## Application for a non-material amendment following a grant of planning permission. Town and Country Planning Act 1990

THE FERNS BECK BANK QUADRING FEN SPALDING  
DEMOLITION OF AN EXISTING BUILDING AND ERECTION  
OF REPLACEMENT BUILDING

H15-0806-24

UPATED ELEVATIONS AND SITE DRAWINGS SHOW REVISED  
PROPOSALS FOR THE SOLAR PANEL ARRANGEMENT.  
ON THE EASTERN ELEVATION THE PREVIOUS LAYOUT OF  
2 ROWS OF 5 PANELS IN LANDSCAPE ORIENTATION  
HAS BEEN CHANGED TO A SINGLE ROW OF 10 PANELS  
IN PORTRAIT ORIENTATION.  
NO OTHER MINOR AMENDMENTS ARE REQUESTED IN  
THIS APPLICATION.

DRAWN REF:	CONTRACT NUMBER:
6472.PL1	2246

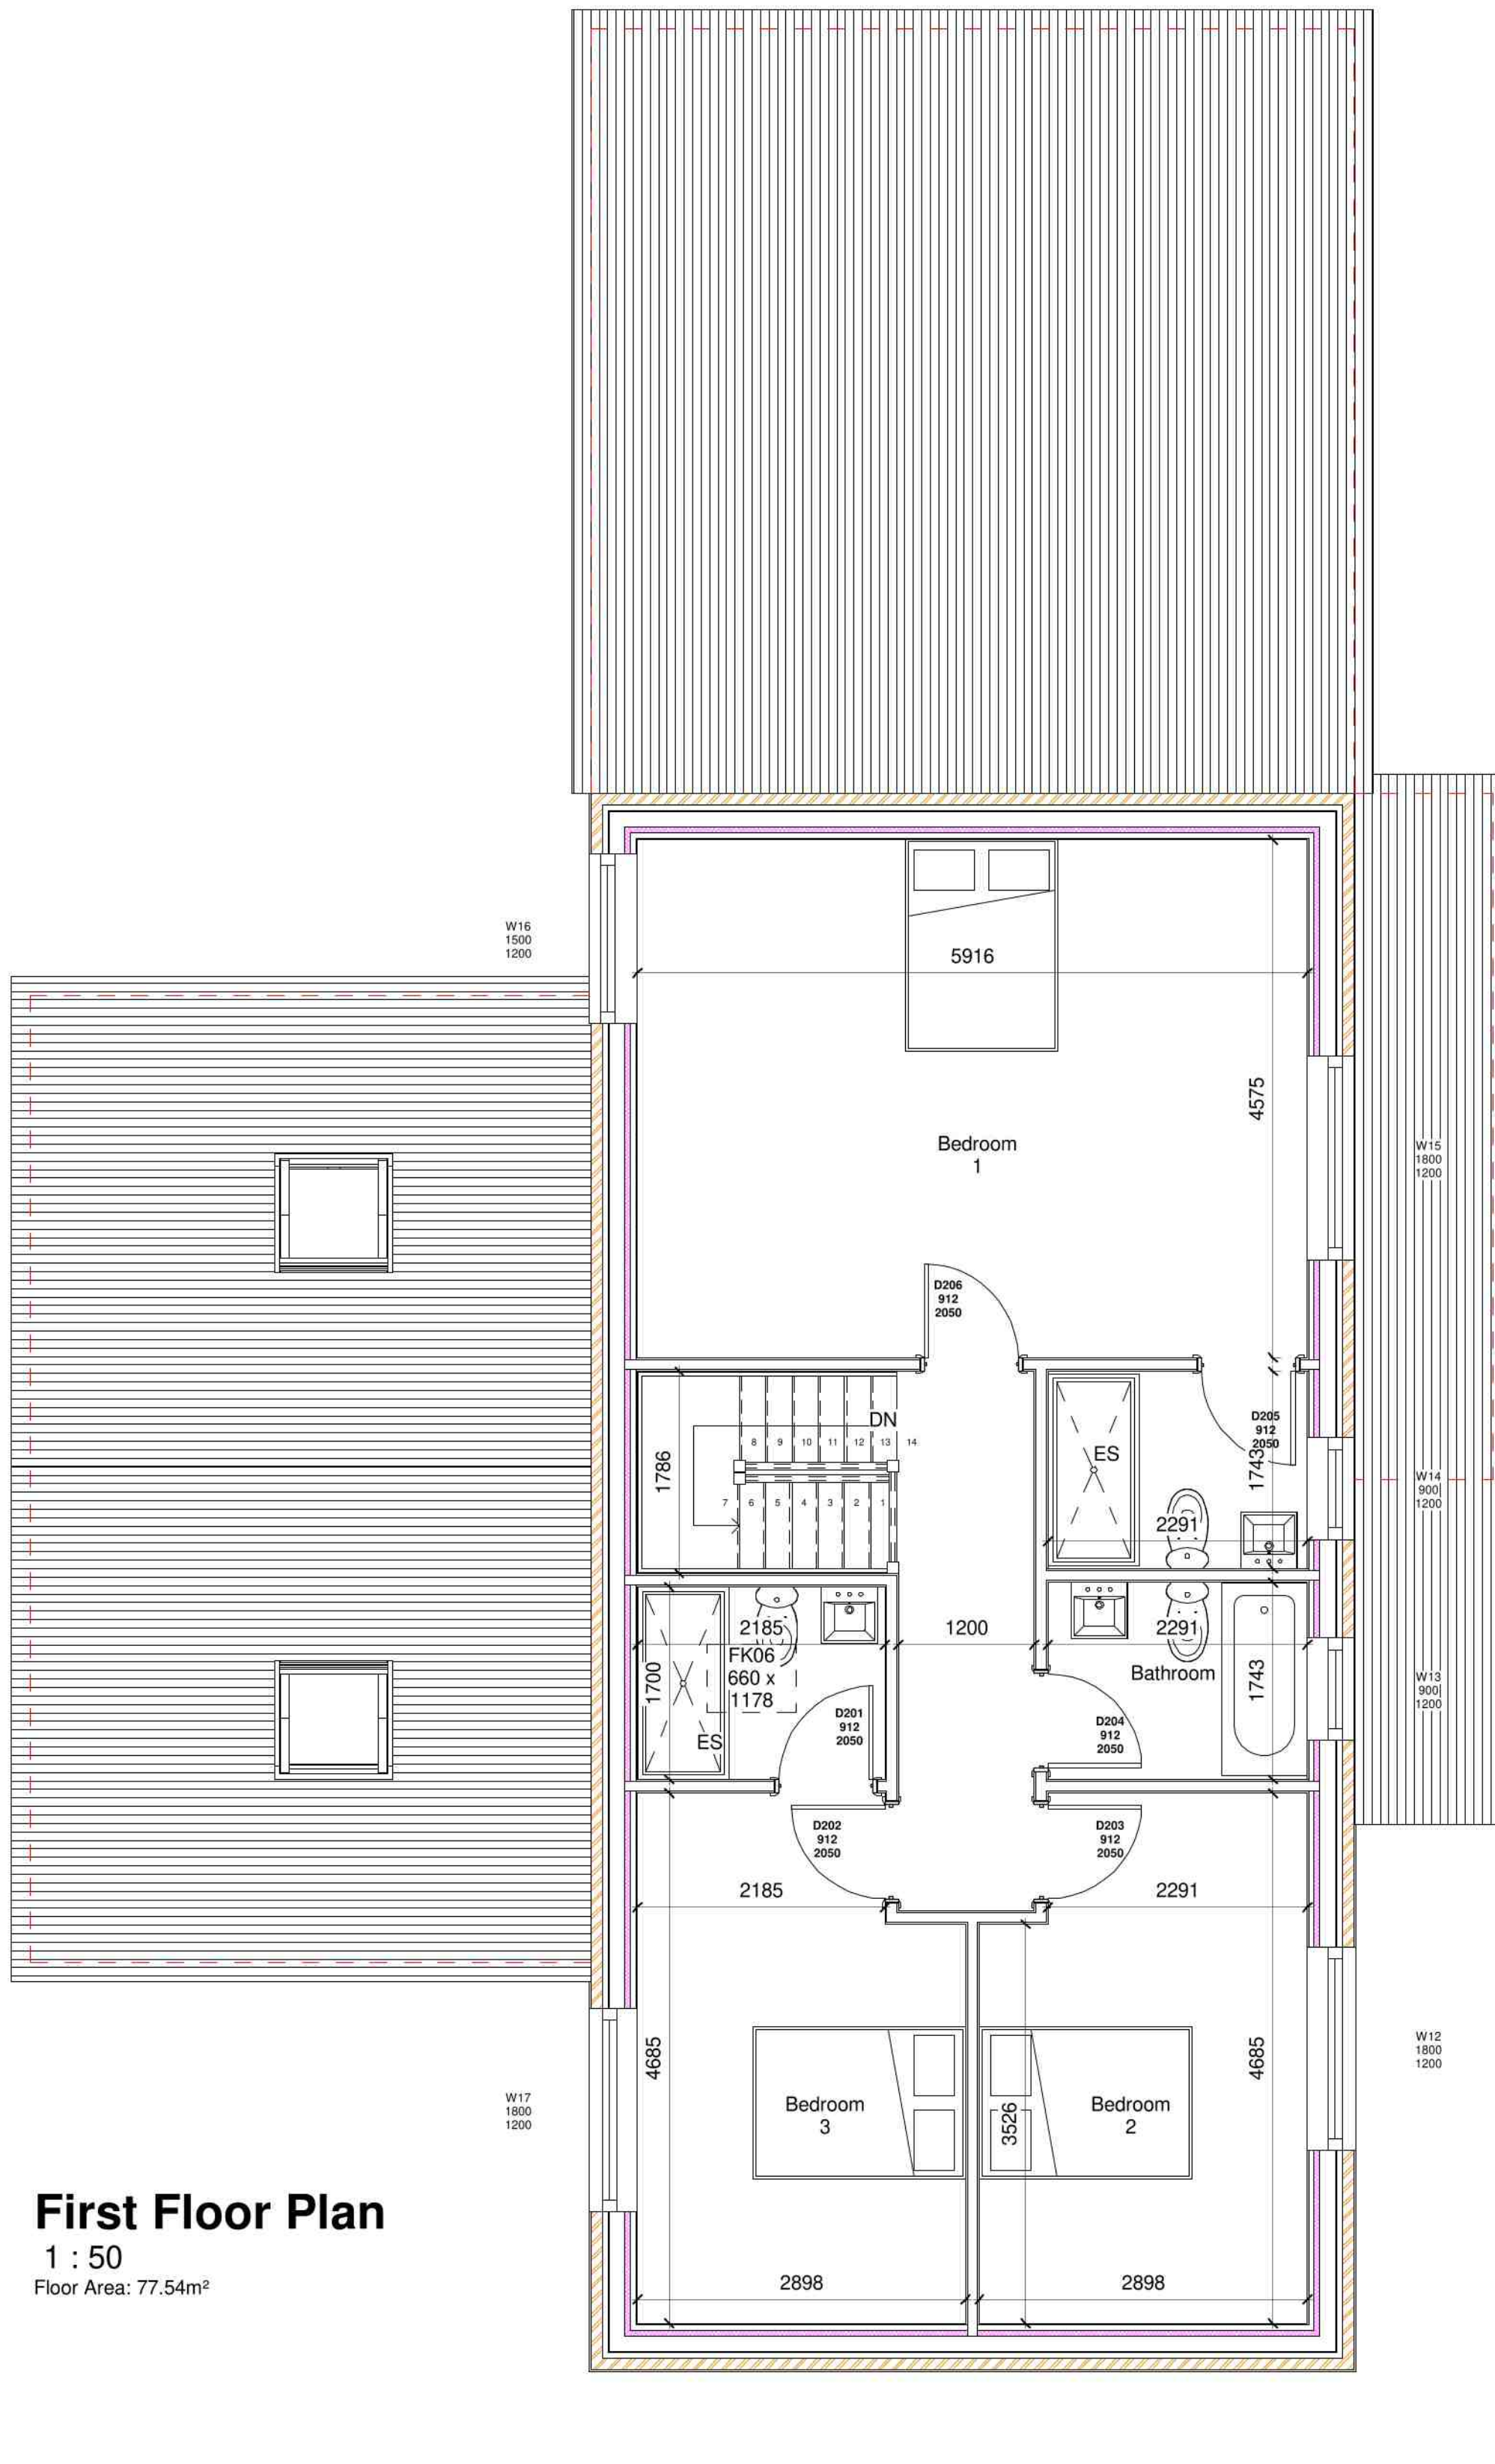
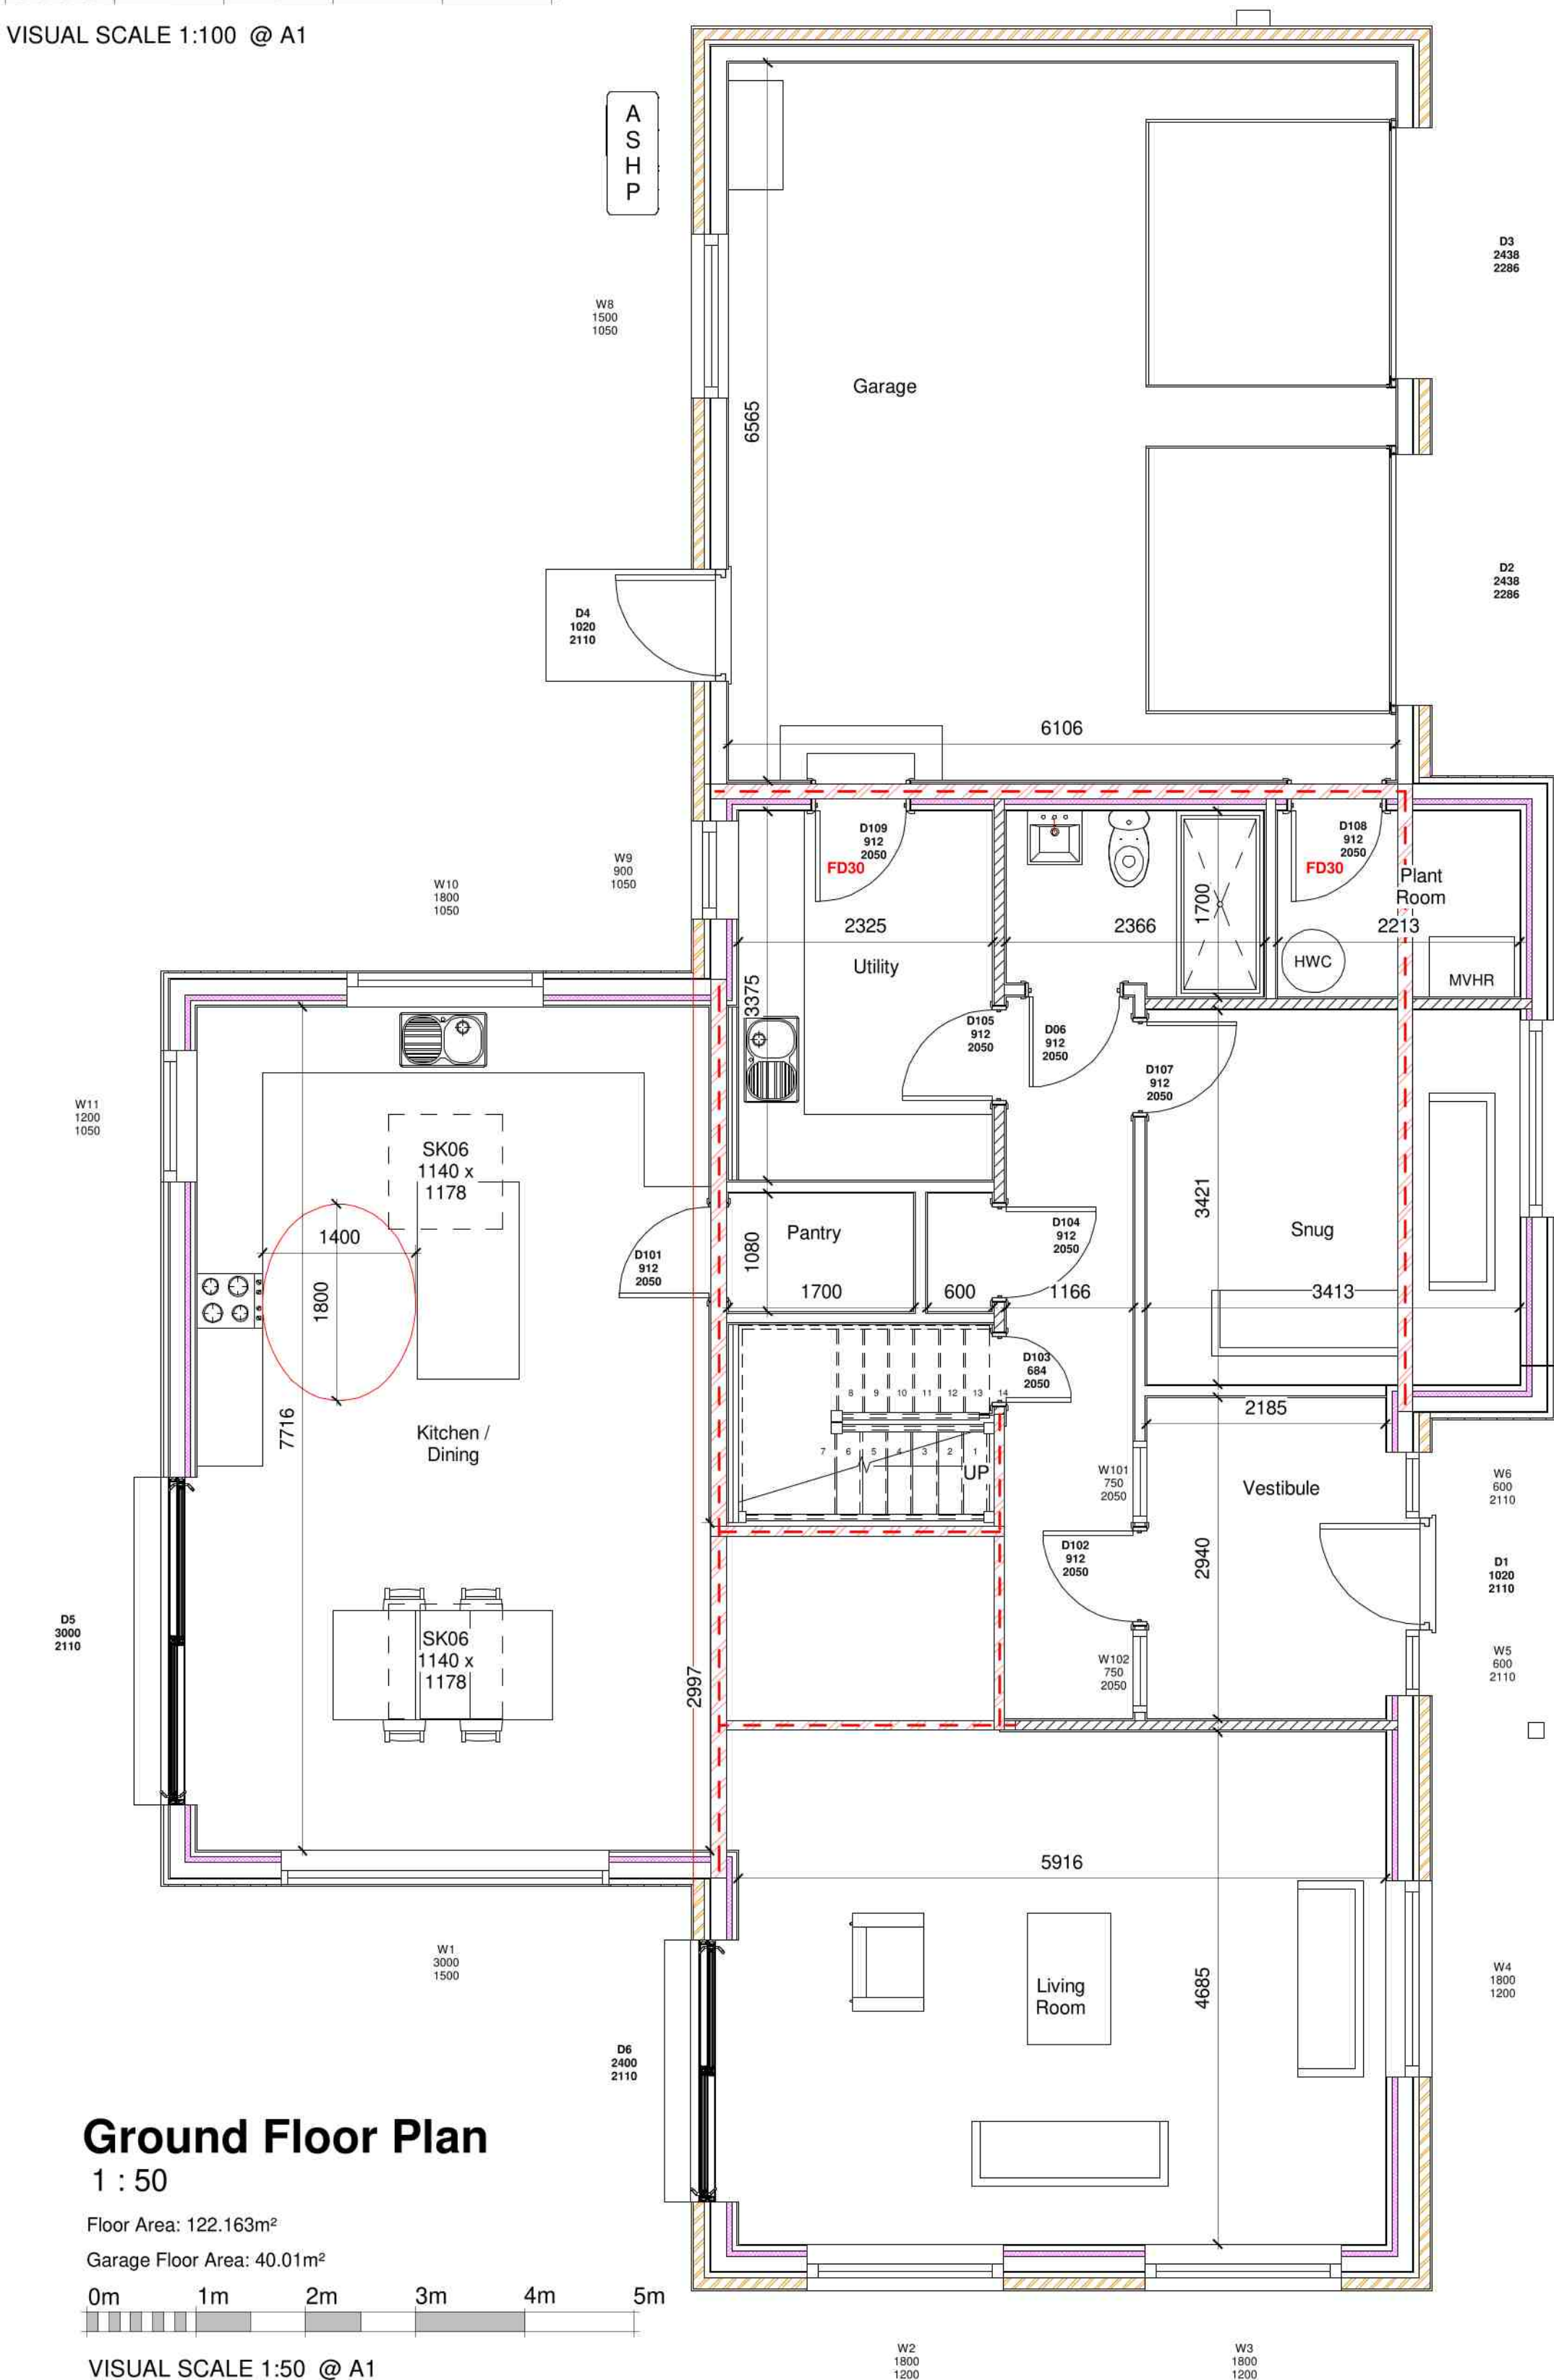
THE MANUFACTURER OF THE SOLAR PANEL ARRAY HAS  
DISCONTINUED THE PRODUCTION OF IN-ROOF FRAMES FOR  
LANDSCAPE ORIENTATED SOLAR PANELS. NO OTHER FRAMES  
COULD BE SUPPLIED APART FROM PORTRAIT ORIENTATED FRAMES  
BY THE MANUFACTURER.

6472.PL1-REV I 17/10/2025 6472.PL2-REV E 17/10/2025
